Request for further information / 11/03/21/HH

We sent you safe versions of your files; 21-1492-PL02B Proposed Details.pdf

We trust the additional dimensions added to the attached Rev B drawing will enable validation.

Proposed Site & Ground Floor Plan

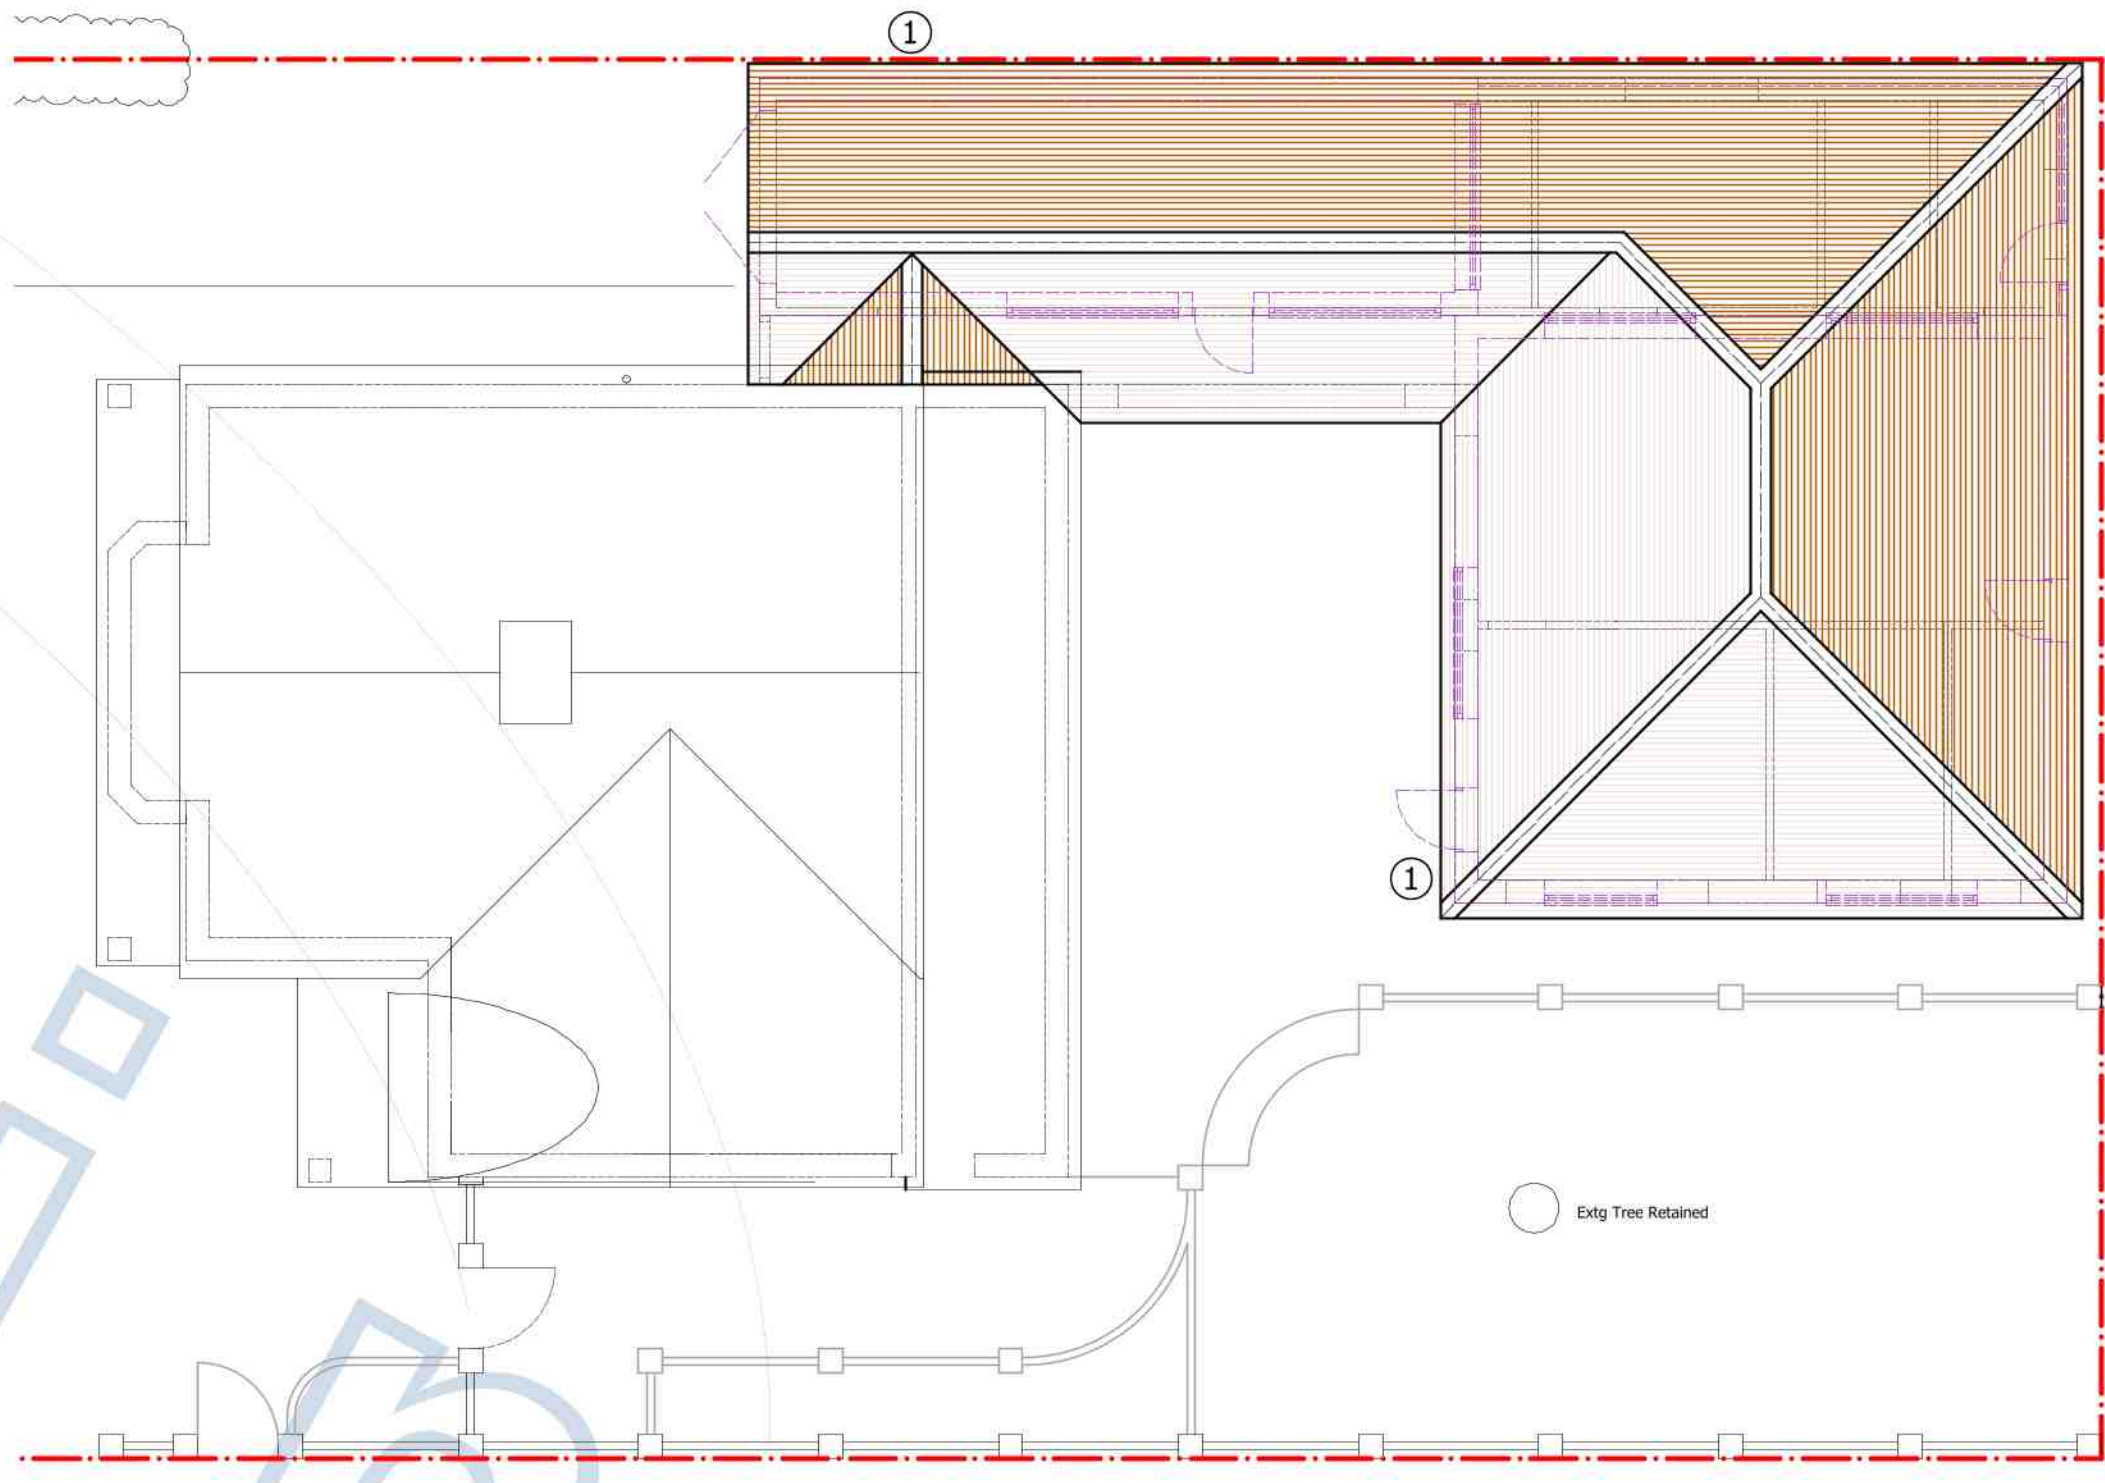
Thank you for your quick response. However, I meant to say the dimensions to all boundaries are required, including the ones facing St Richard's Way and Gossamer Lane.

Thank you for providing the amended plan. However, the dimension to the side boundary is also required. Please amend.

We have added dimensions to both side boundaries, as shown on the extract below.

Please find attached updated drawing with dimensions to the site boundary from the external wall face
Attached 21-1492-PL02A Proposed Details.
